City of Albuquerque Stormwater Construction Site Inspection Report

ESC File No.	B10E003I		Project Name:	Dutch Brothers	
NPDES Id. No.	NMRI004B5 & NMRI004B6		Location:	9600 Universe Blvd	
4/6/2022	Owner		Contractor		
Operator	Diamond Trail Realty, LLC		Franklins		
Contact name & title	Ryan growney		John Ellis		
e-mail	rgrowney@growney-inc.com		John.ellis@feinm.com		
Contact Phone #	850-2427		884-6947		
COA Inspector	Doug Hughes		Start/End Time:	2pm	
Construction Phase:	infrastructure nearly complete				
Type of Inspection:	<input type="checkbox"/> Regular	<input type="checkbox"/> Storm Event	<input type="checkbox"/> Post Storm Event >0.25"	<input type="checkbox"/> 311/Complaint	<input type="checkbox"/> Follow Up
Weather at time of inspection?	Clear		Temperature: ~	73	
Estimated date of last storm 0.25" or greater	3/23/2022

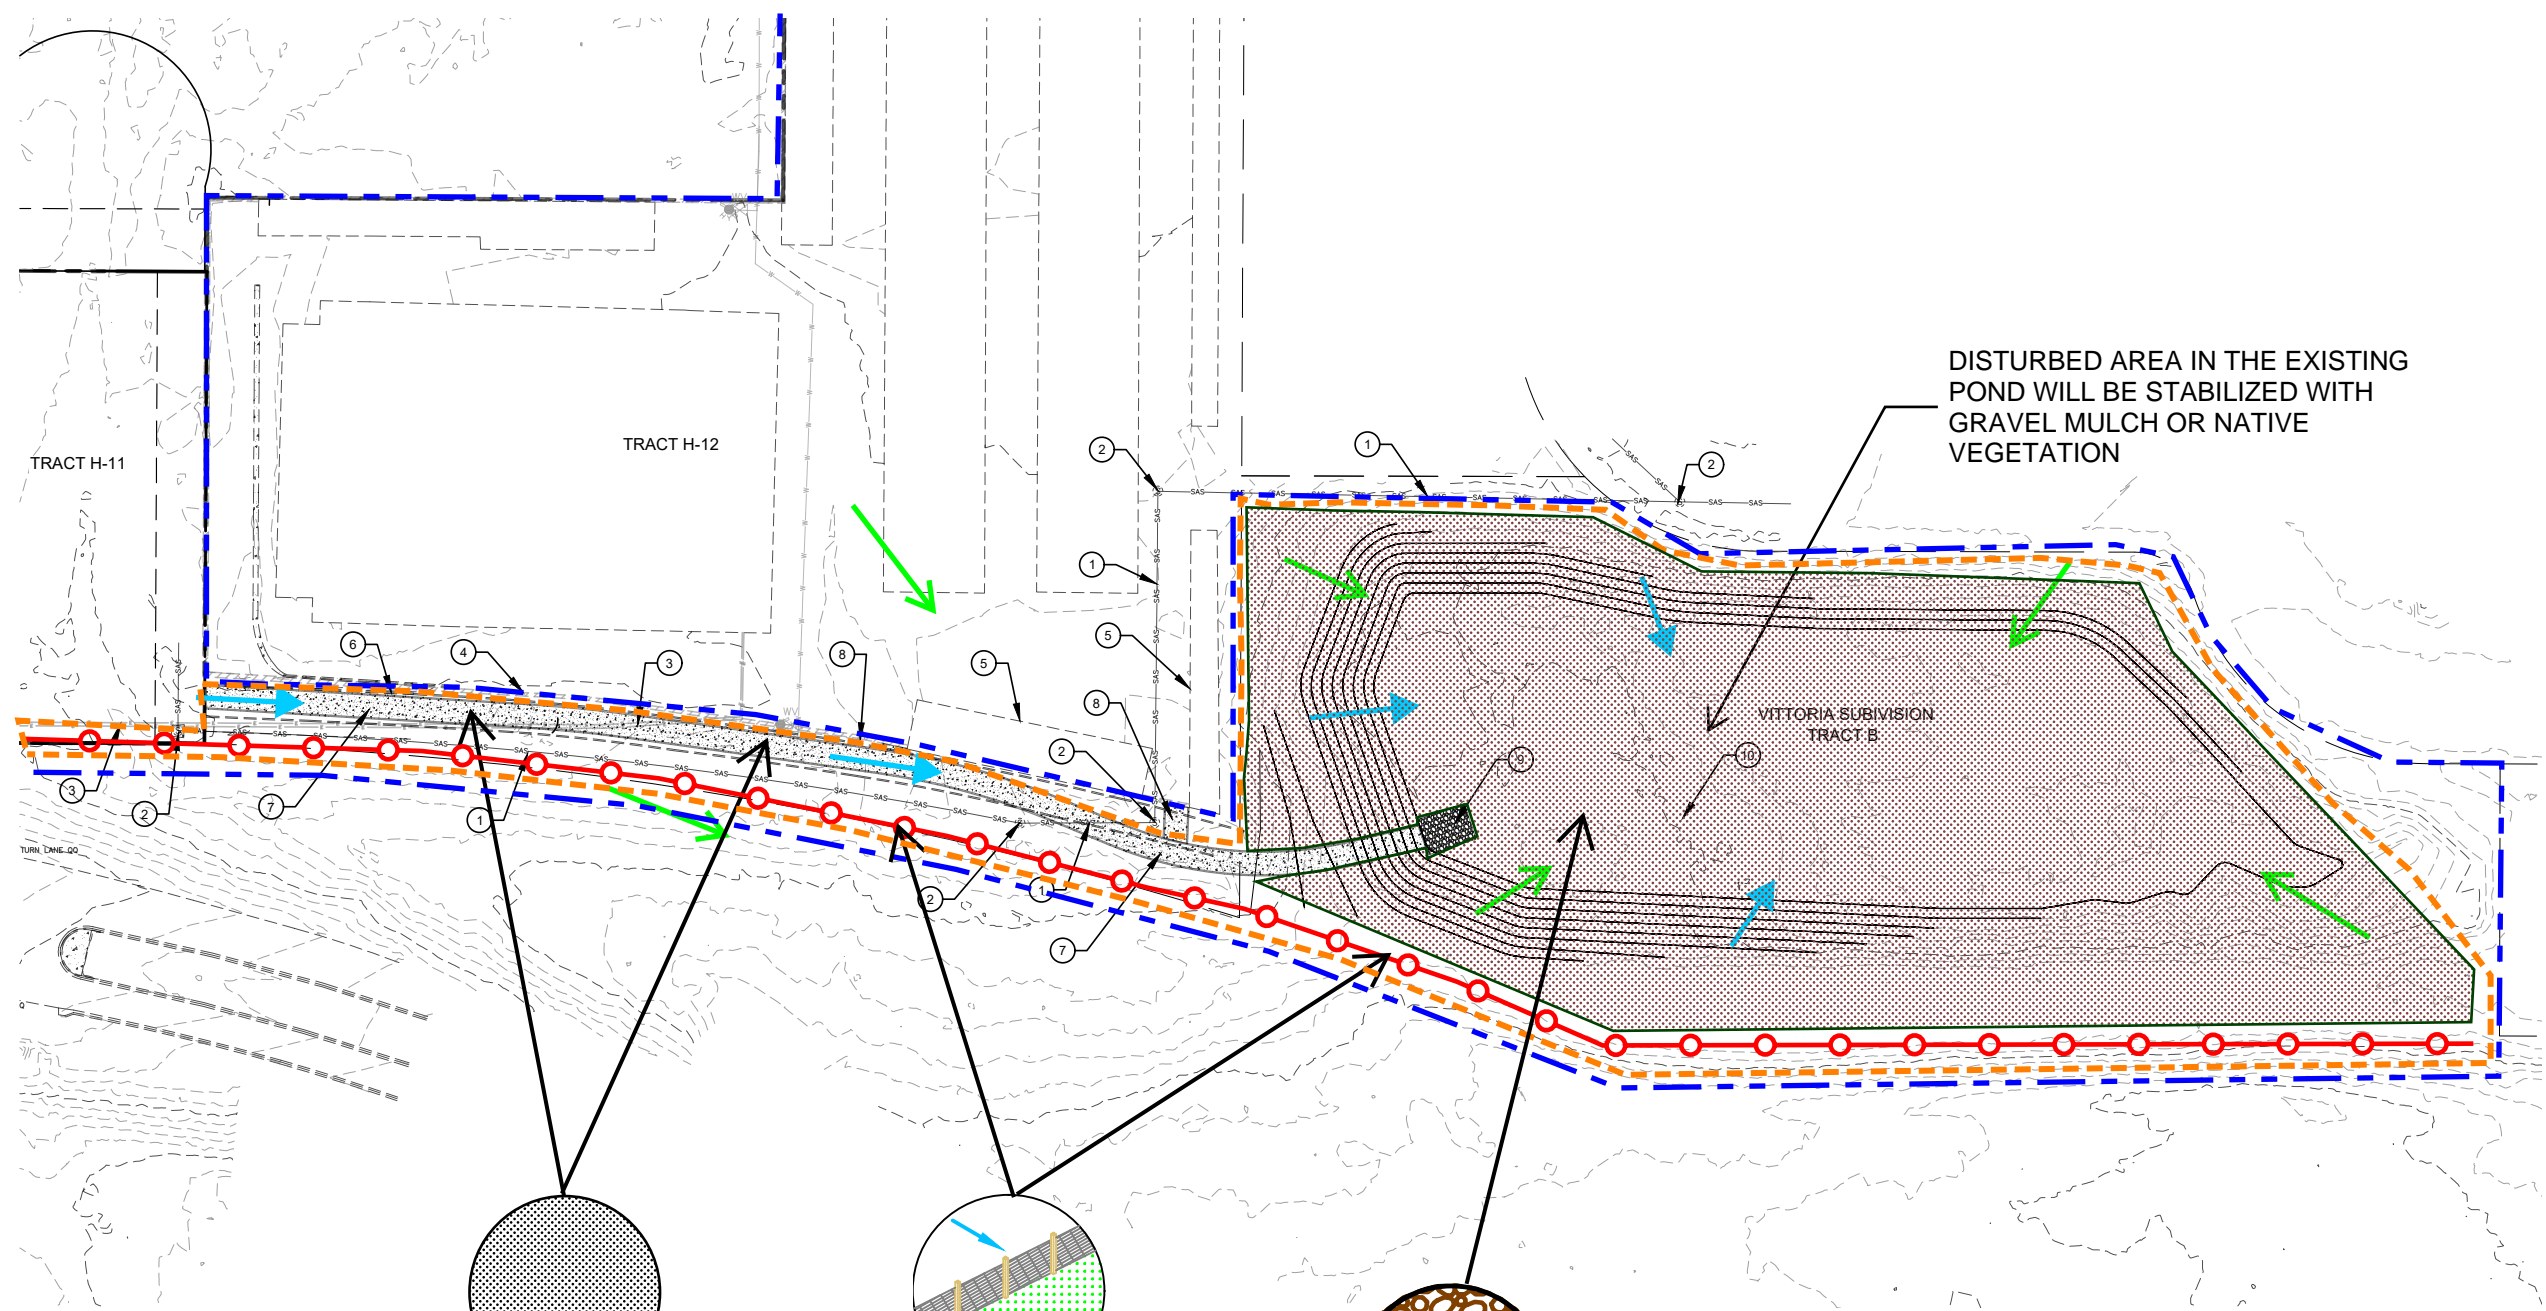
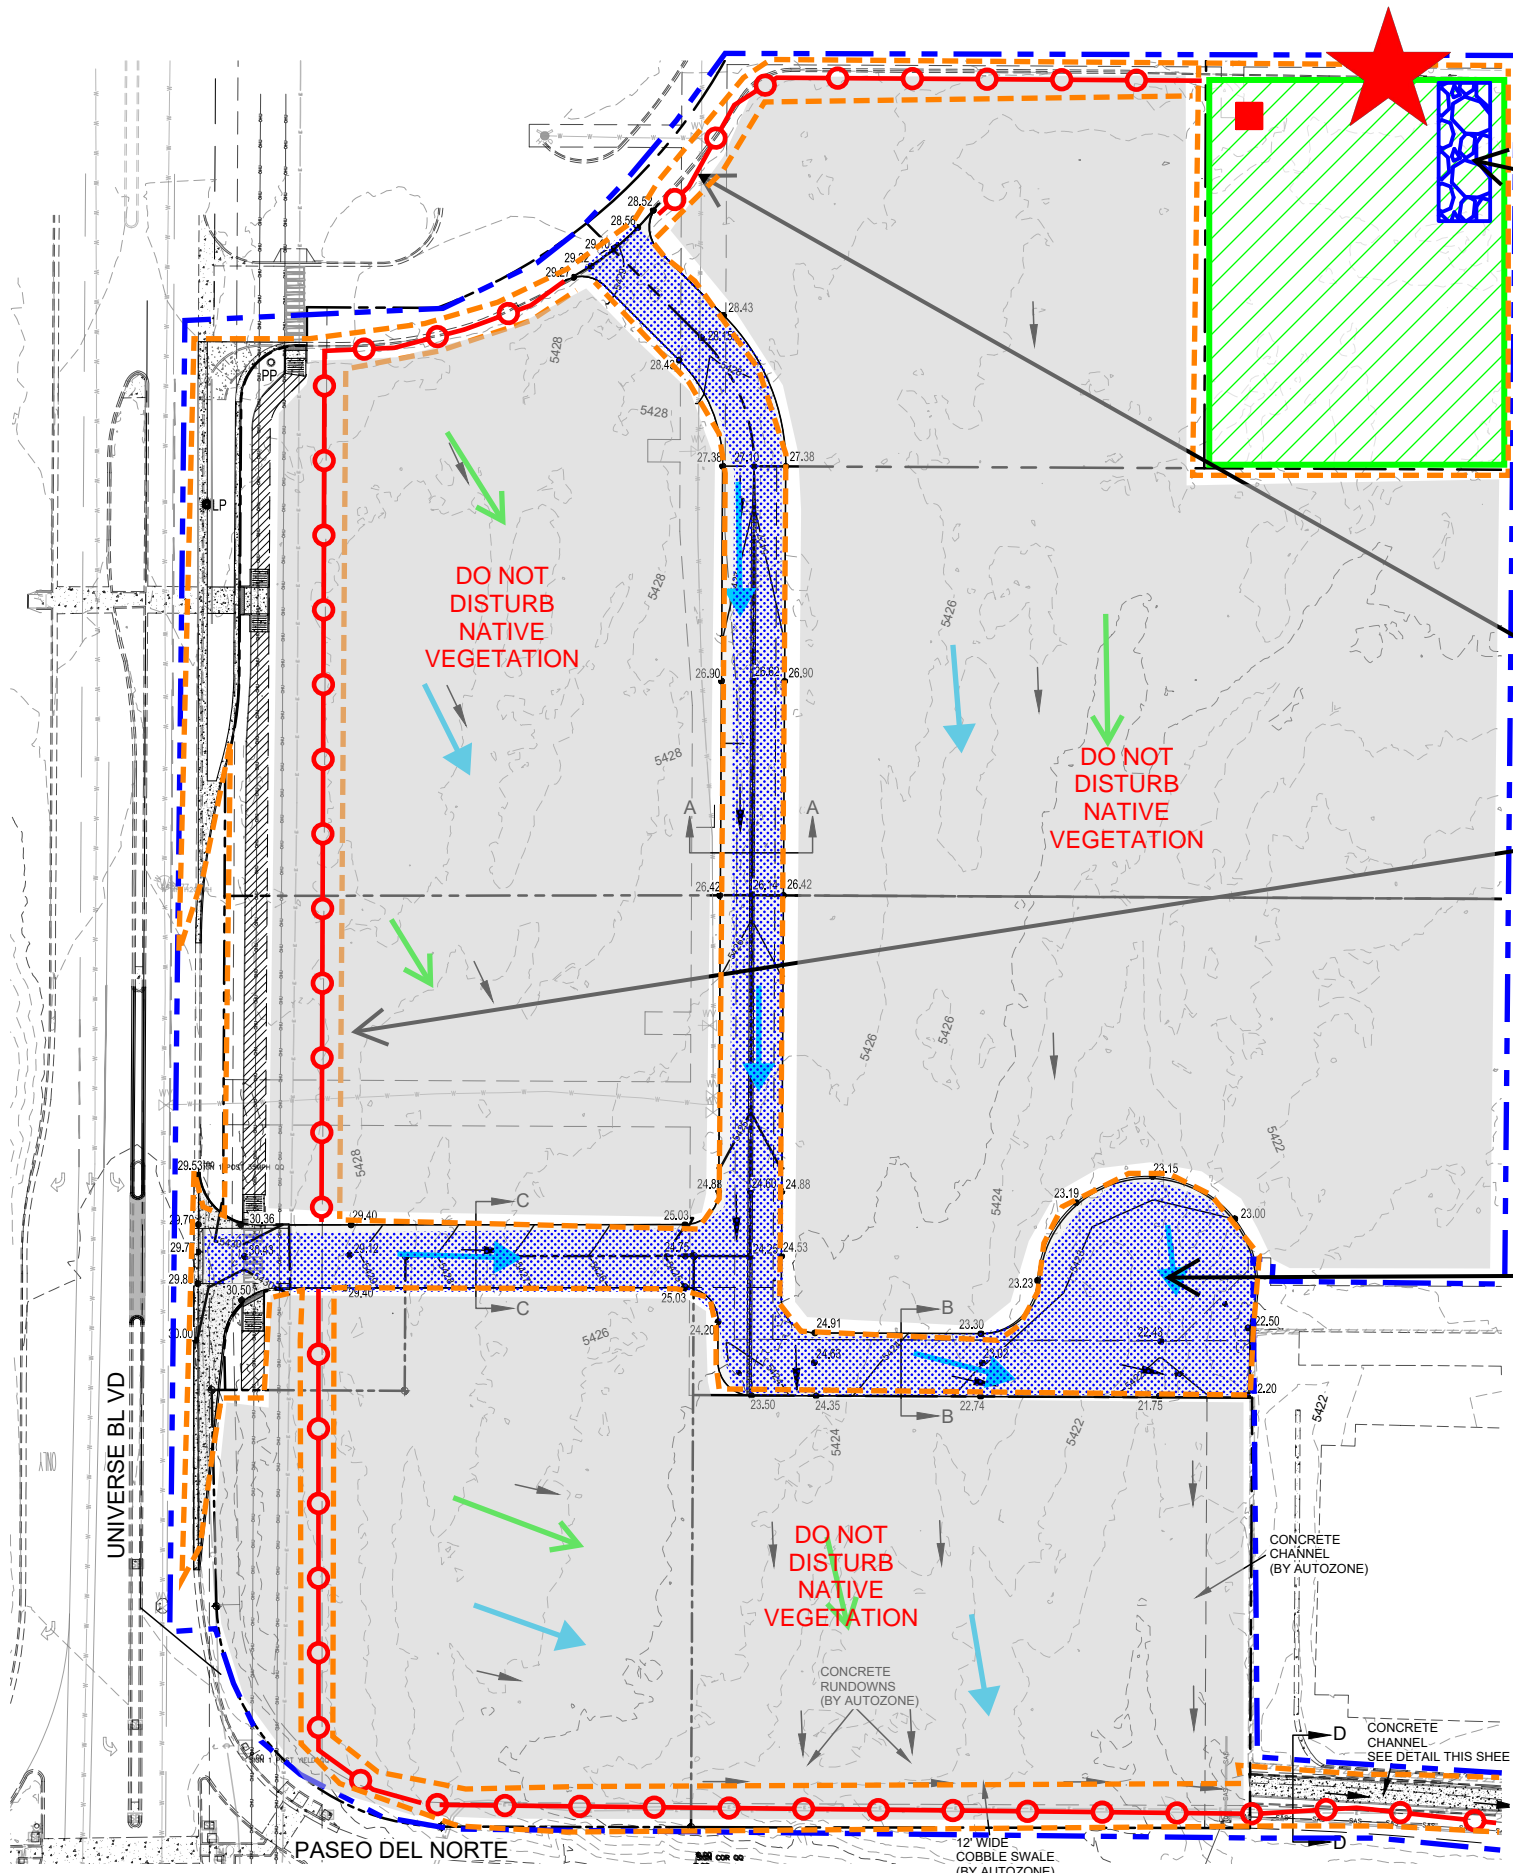
Notes:	
<p>Ralph.maestas@feinm.com and Guillermo.rosales@FEINM>com have the me the SWPPP in truck on-site. It was up-to-date, posting is on staging area fence. Limits of Disturbance is more than shown on plan so additional stabilization needed. BMPs OK, and no sediment.</p>	
<p>2017 CGP and NOI needs updated to 2022.</p>	
<p></p>
